Our Ref: **BR/63/12/**
Your Ref:

Application for Planning Permission

Development Small modification to existing roof, to replace section of flat roof with pitched roof to match remainder of existing. Increase second floor by 5 square metres, replace existing east facing window with roof light & 3 additional roof lights. Replace existing timber window on north elevation

Location 3 Elfin Grove Bognor Regis

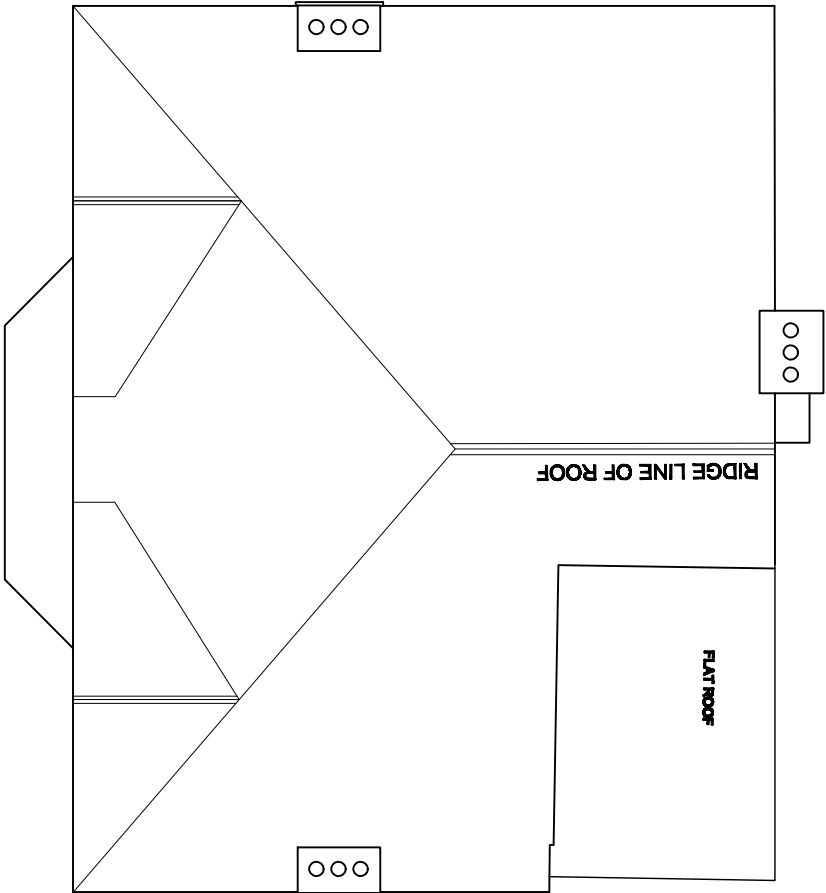
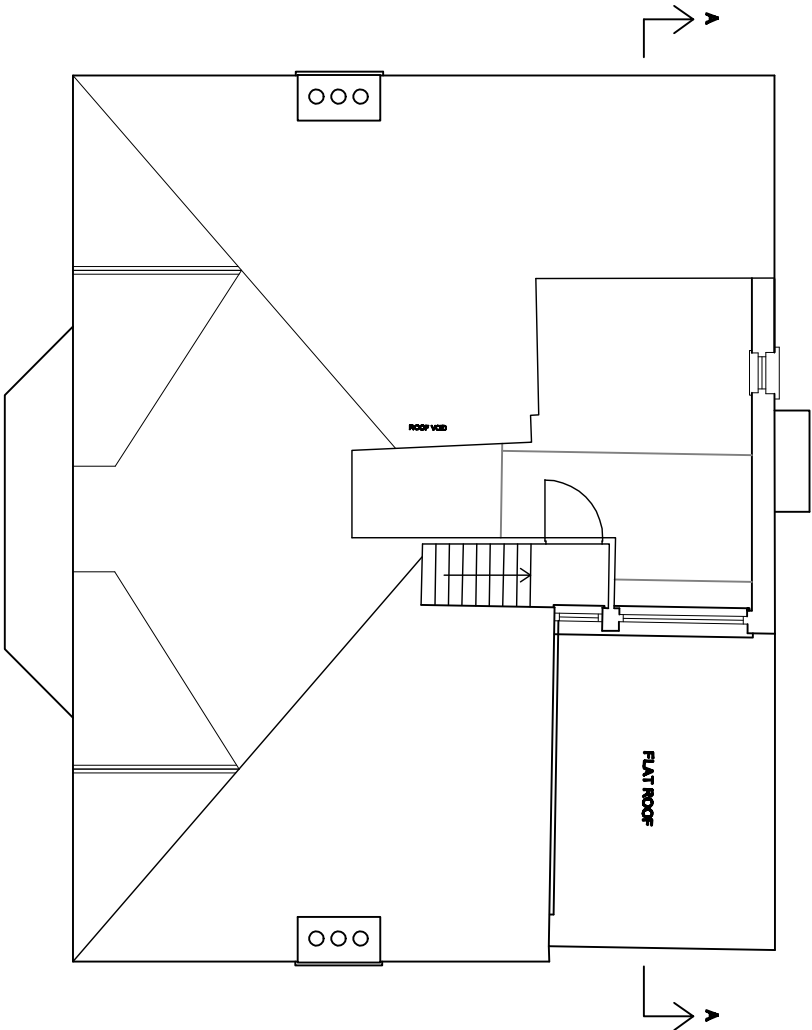
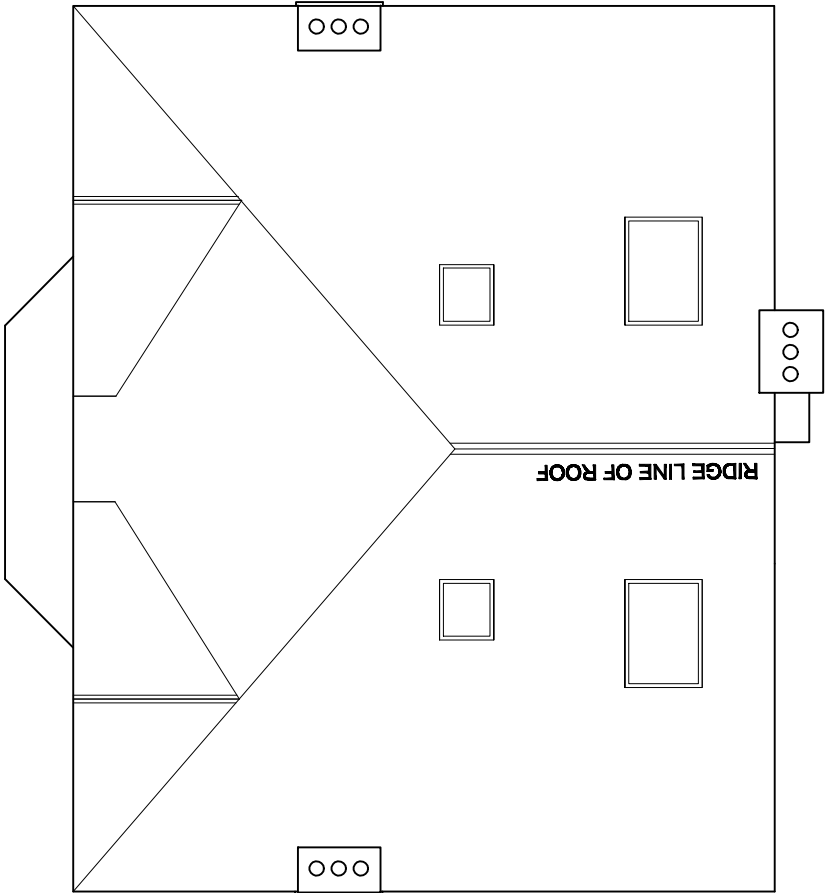
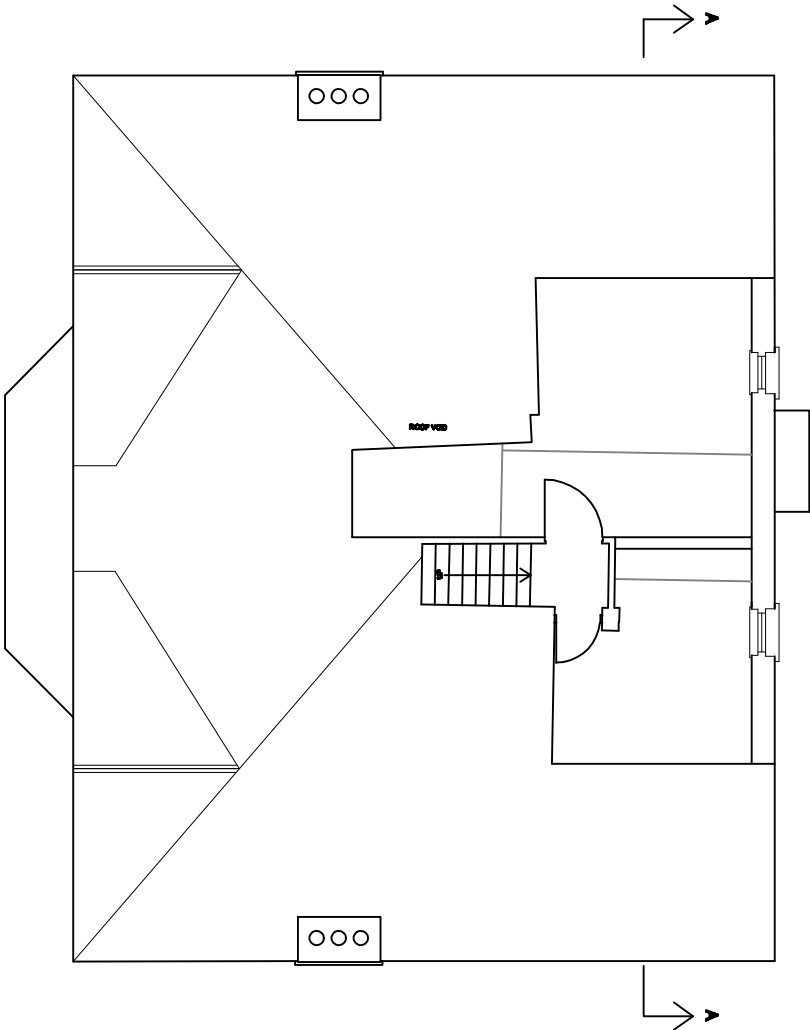
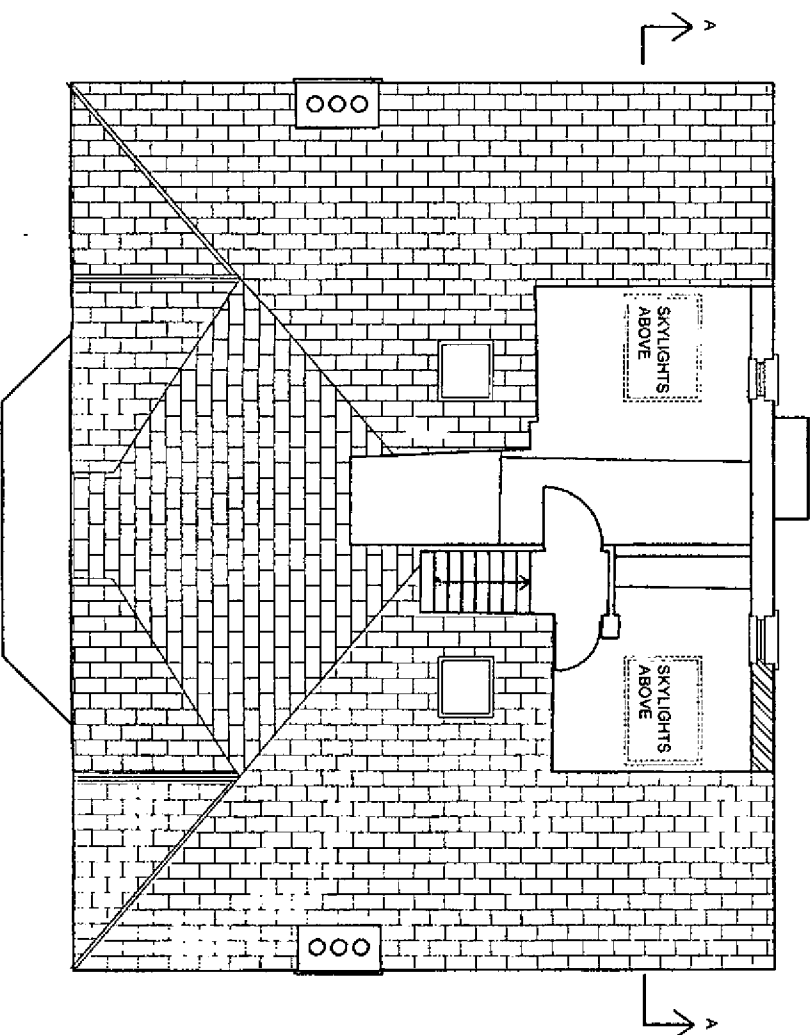
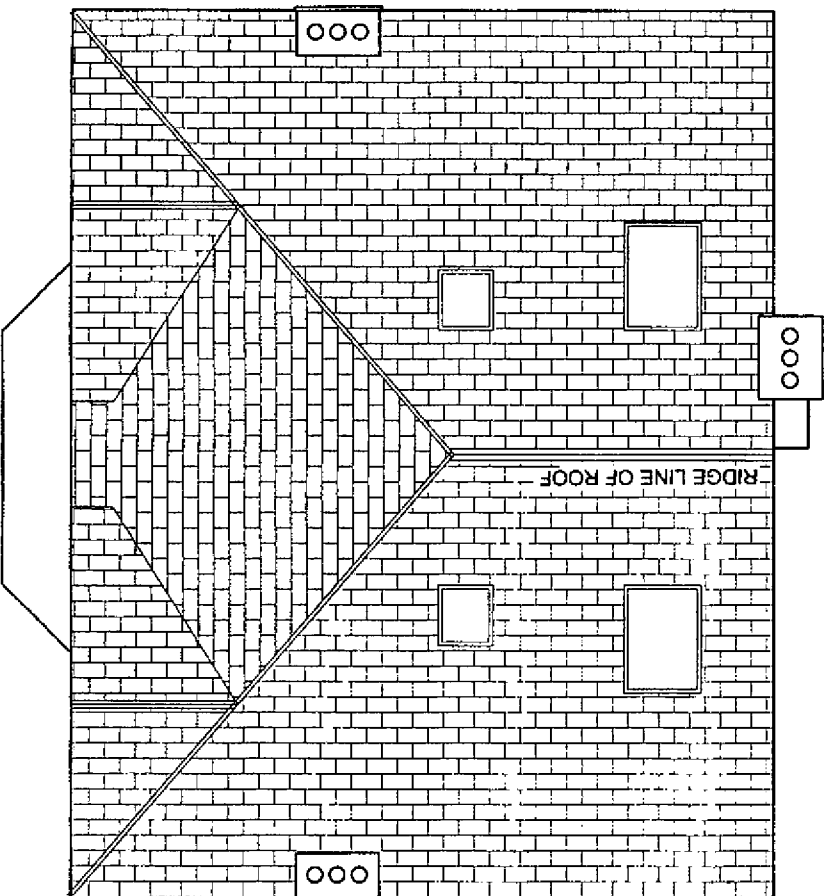
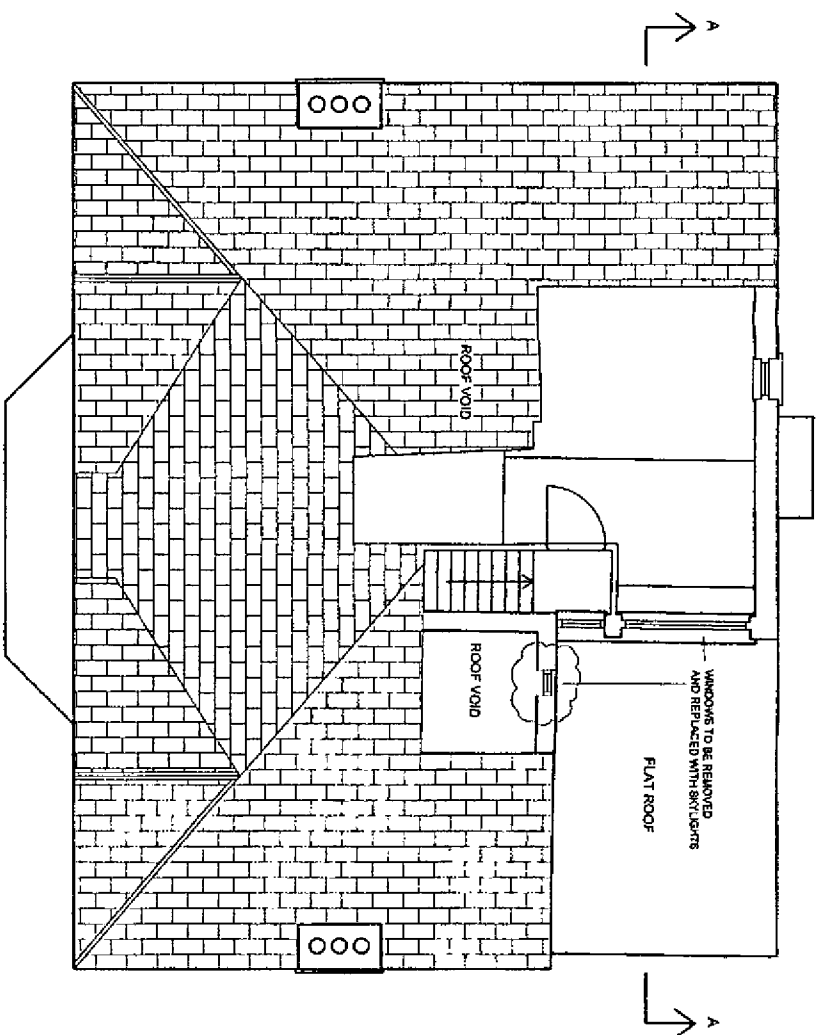
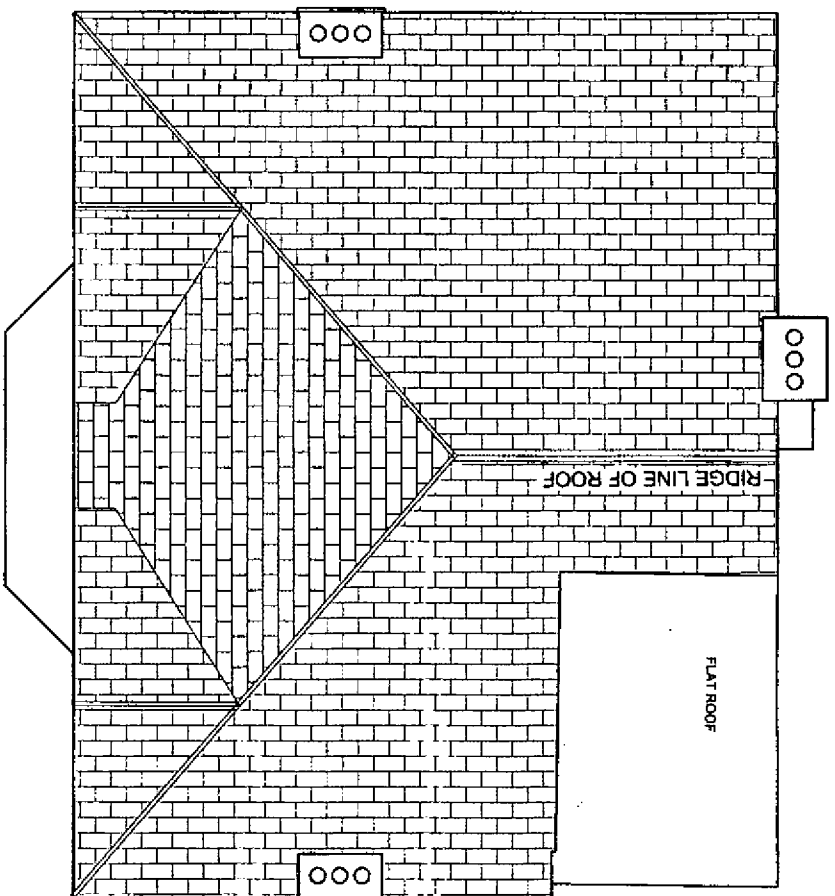
Please provide 1 electronic or 3 paper copies of revised existing and proposed floor plans to show all the windows (including roof lights) as detailed on the elevations.

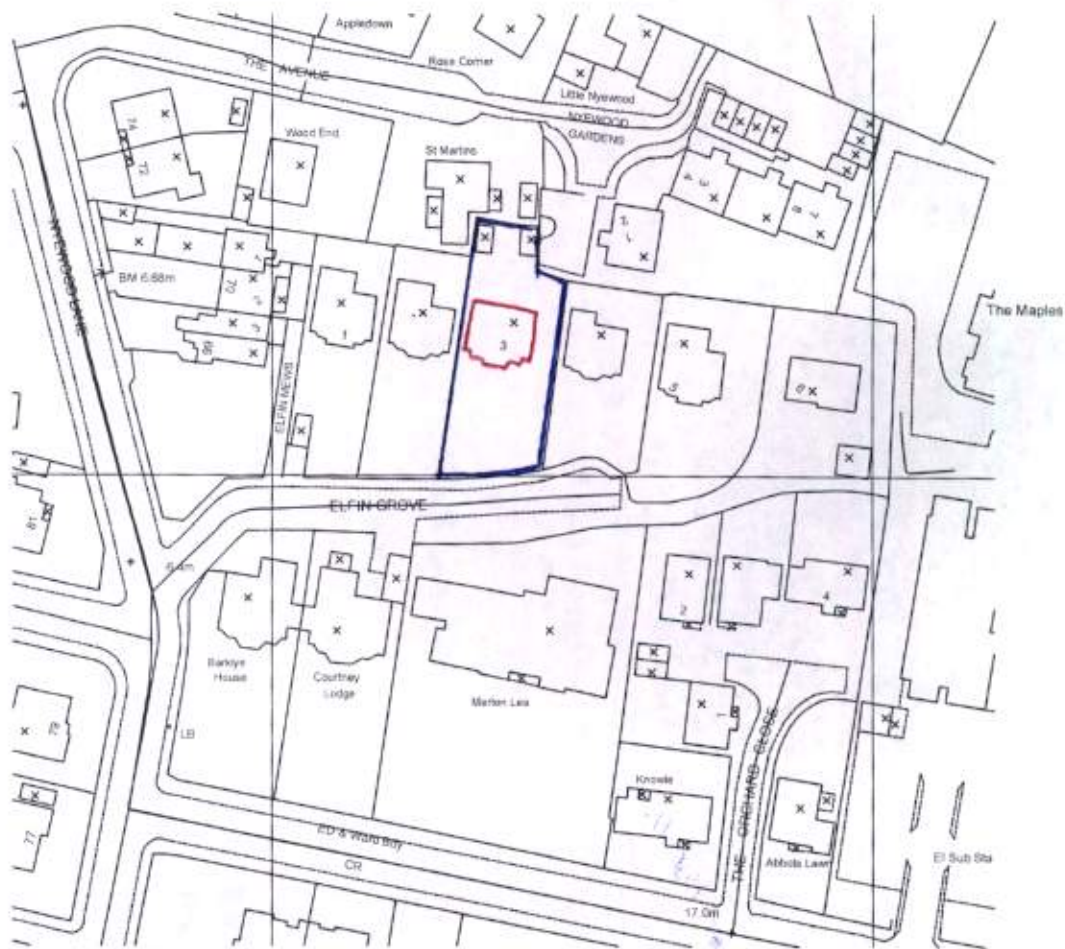
I require 1 electronic or 3 paper copies of a revised location plan showing area edge around the application site, in accordance with the guidance notes available on our website detailed below (click on National List).
